Re: Pavement Recommendations
Sterling Ranch, Filing No. 2
El Paso County, Colorado

APPROVED
Engineering Department

EPC Planning & Community
Development Department

**BEAVERHEAD CIRCLE**  
**STA 3+00.00 TO STA 8+77.00**

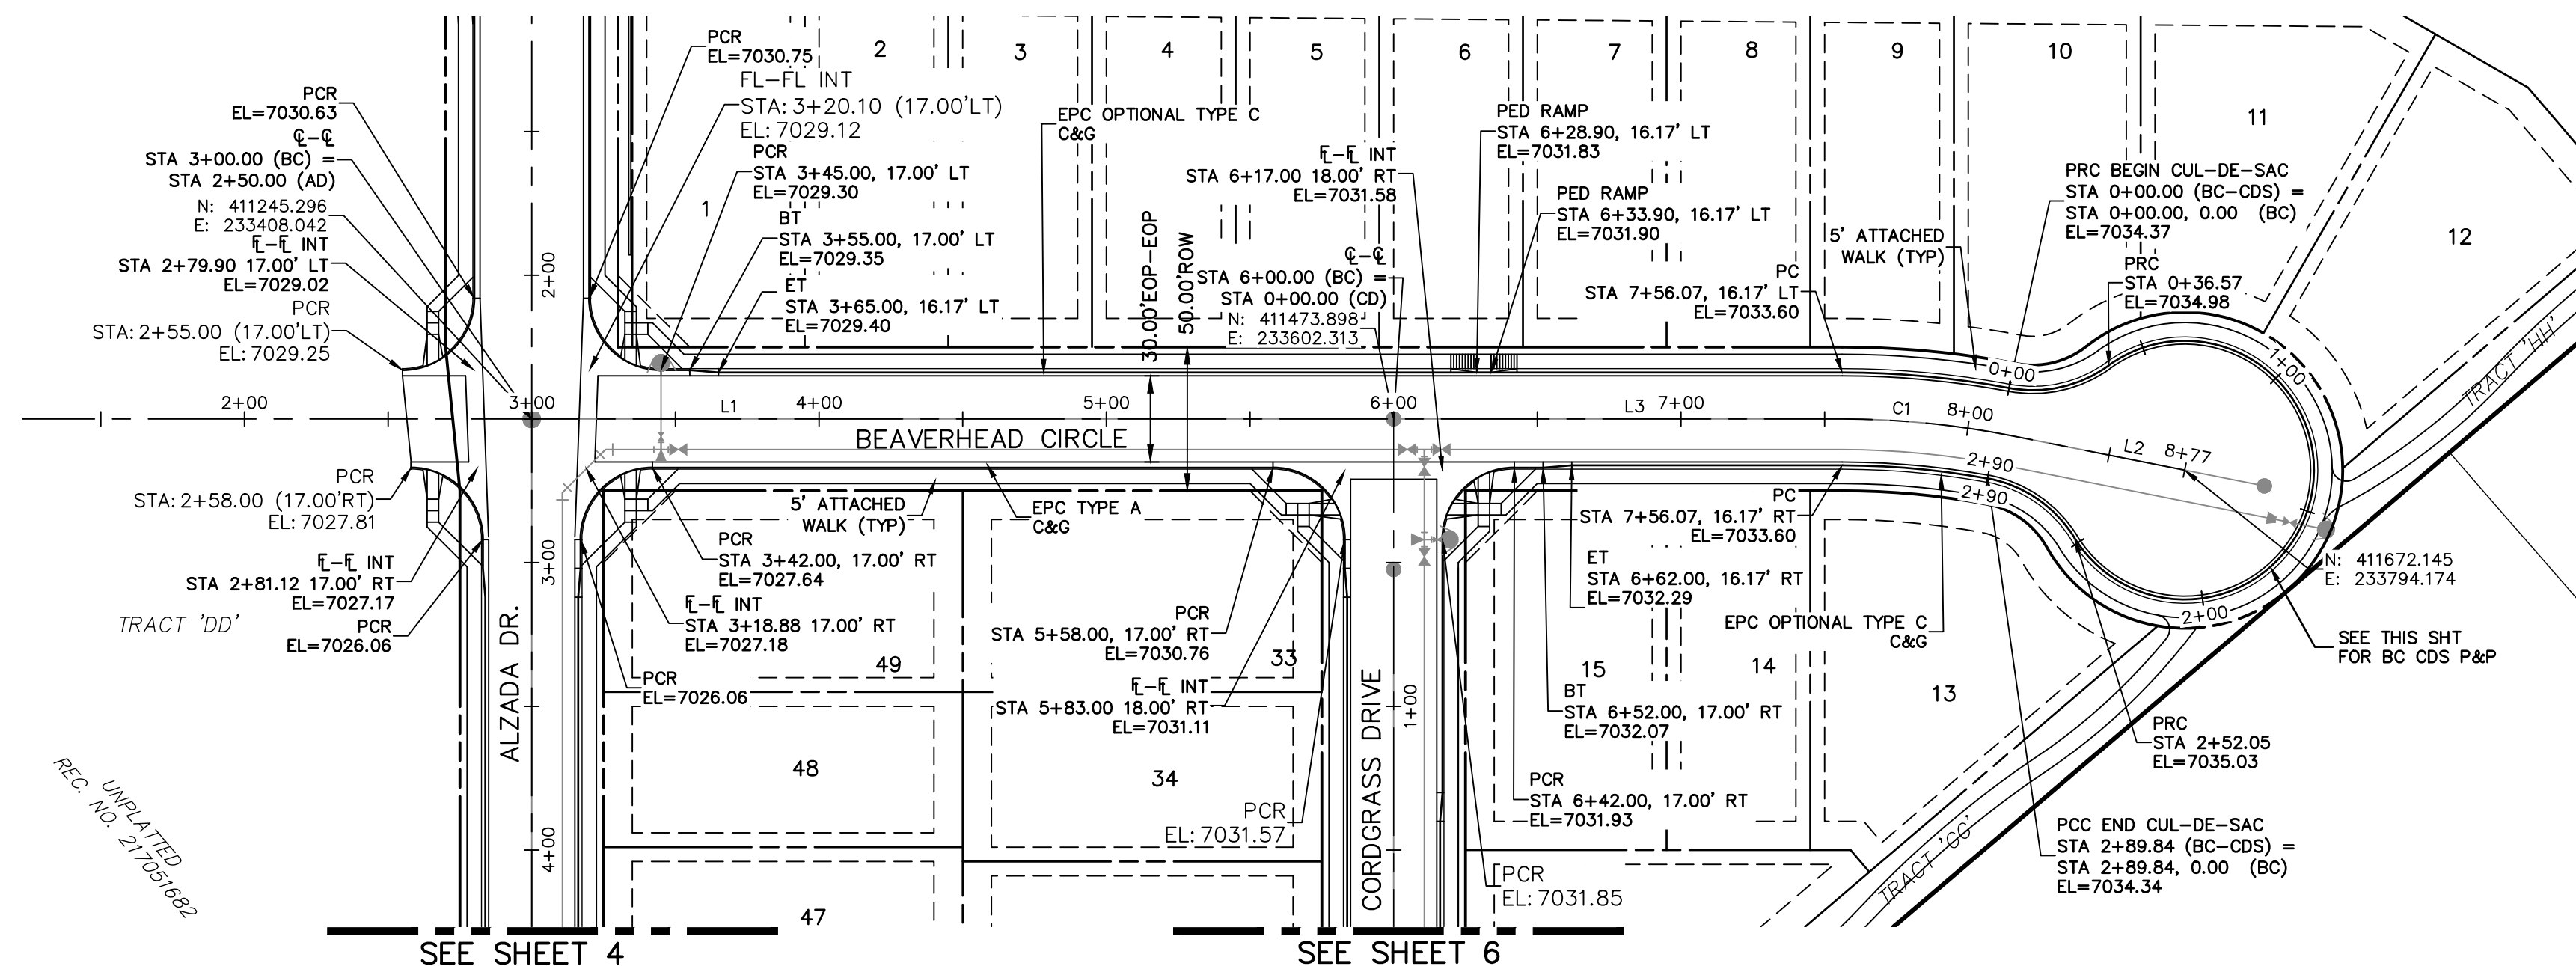
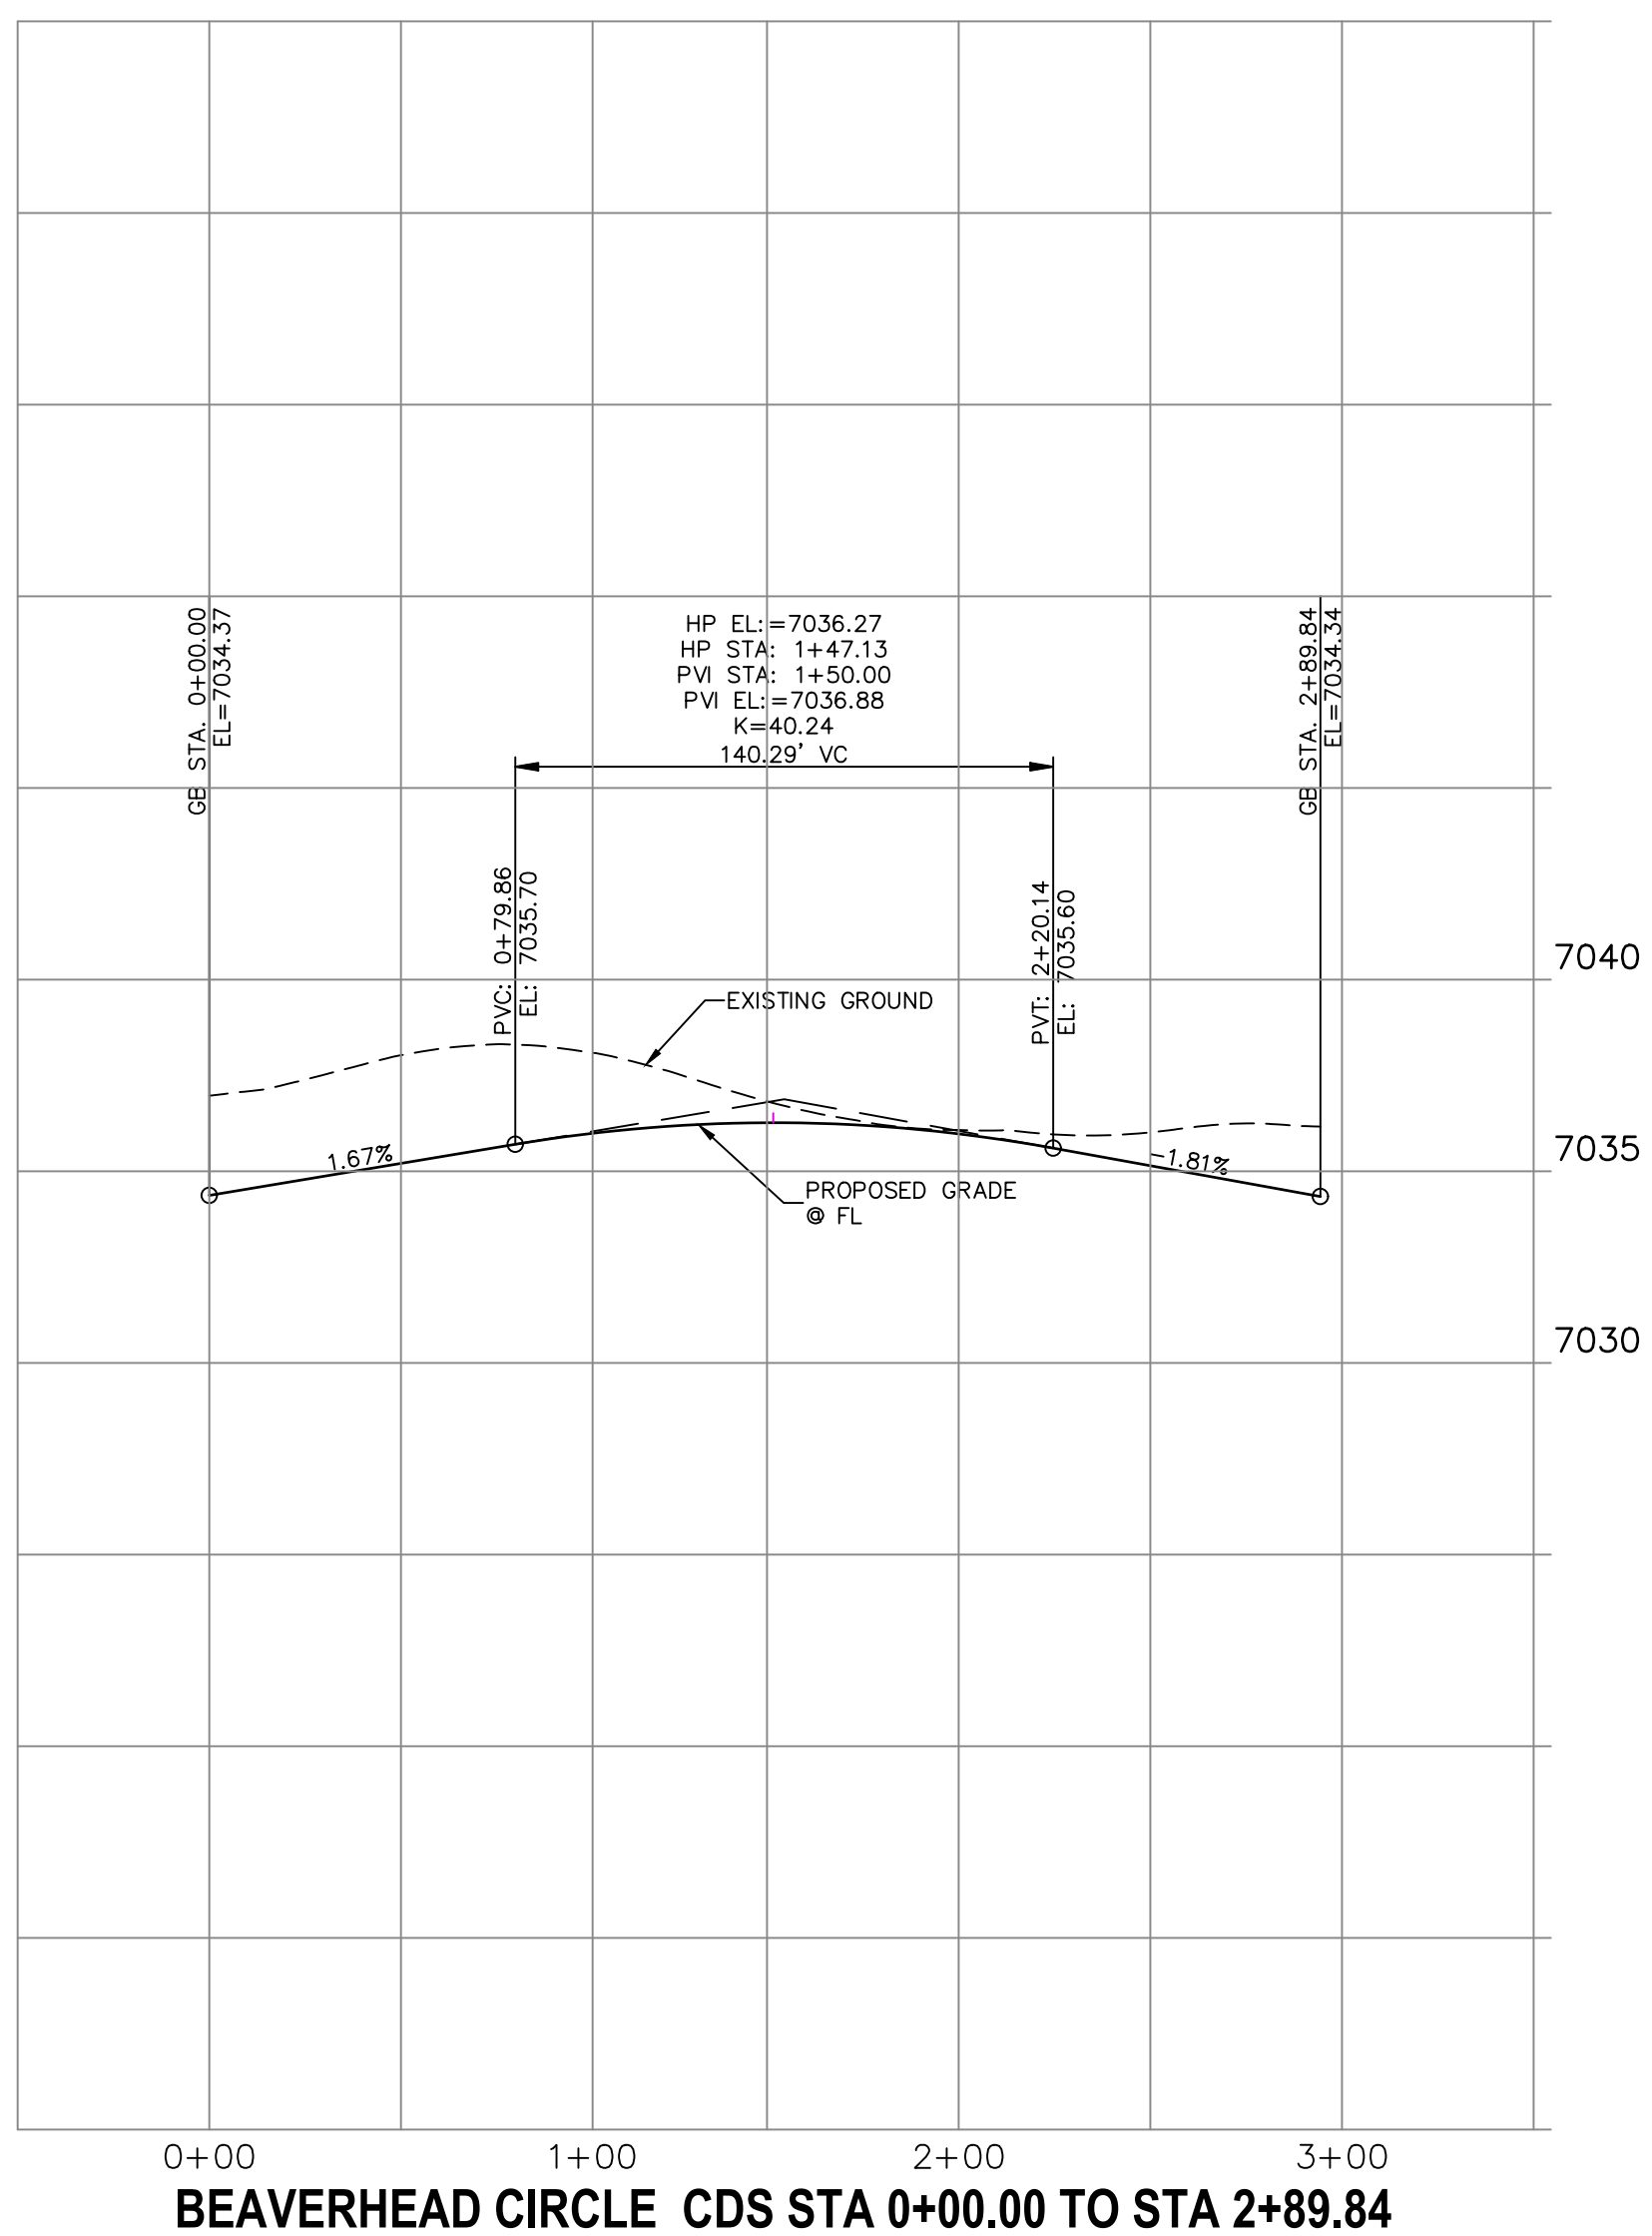
***asphalt millings and full depth
are not acceptable-- EN, PCD**

CBR testing was used to determine pavement sections for the roadway sections. Pavement sections were determined utilizing Pavement Design Criteria for the El Paso County. The cul-de-sac portion of Beaverhead Circle classifies as a local low-volume road, which used an 18k ESAL value of 36,500 for design. Bynum Drive, Cordgrass Drive, and Beaverhead Circle from Alzada Drive to Cordgrass Drive classify as local roads, which used an 18k ESAL volume of 292,000 for design. Alzada Drive classifies as a residential collector, which used on 18K ESAL value of 821,000 for design. Pavement sections were determined for asphalt supported on aggregate base course, asphalt millings, and on recycled concrete. County approval is required if asphalt millings or recycled concrete are to be utilized. ***asphalt millings and full depth are not acceptable, EN, PCD**
